TOWN AND COUNTRY PLANNING ACT 1990

FULL

Reference: H05-0004-25 **Date of Decision:** 7th February 2025
Applicant: Mr & Mrs Banhire
Cherry Trees
2 Joys Bank
Holbeach St Johns
Spalding
PE12 8SD
Location: Cherry Trees 2 Joys Bank Holbeach St Johns Spalding
Description: Proposed two storey rear extension

PROPOSED SIDE ELEVATION (EAST)

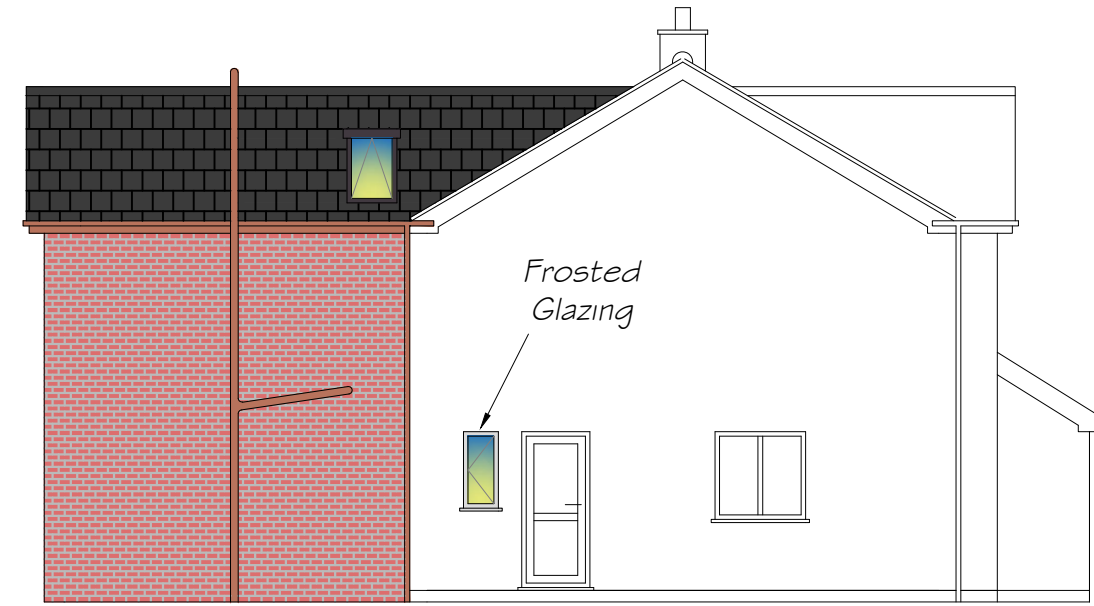
- 3 Notwithstanding the details submitted, before any part of the development hereby

permitted is occupied, the following window(s) shall be installed with obscure glazing (to a minimum level of Pilkington - Privacy Level 3 or an equivalent product) and shall have no opening part being less than 1.7m above the floor level immediately below the centre of the opening part.

- Ground floor eastern side elevation window which is connected to a bathroom.

Once installed, the window shall thereafter be retained as such.
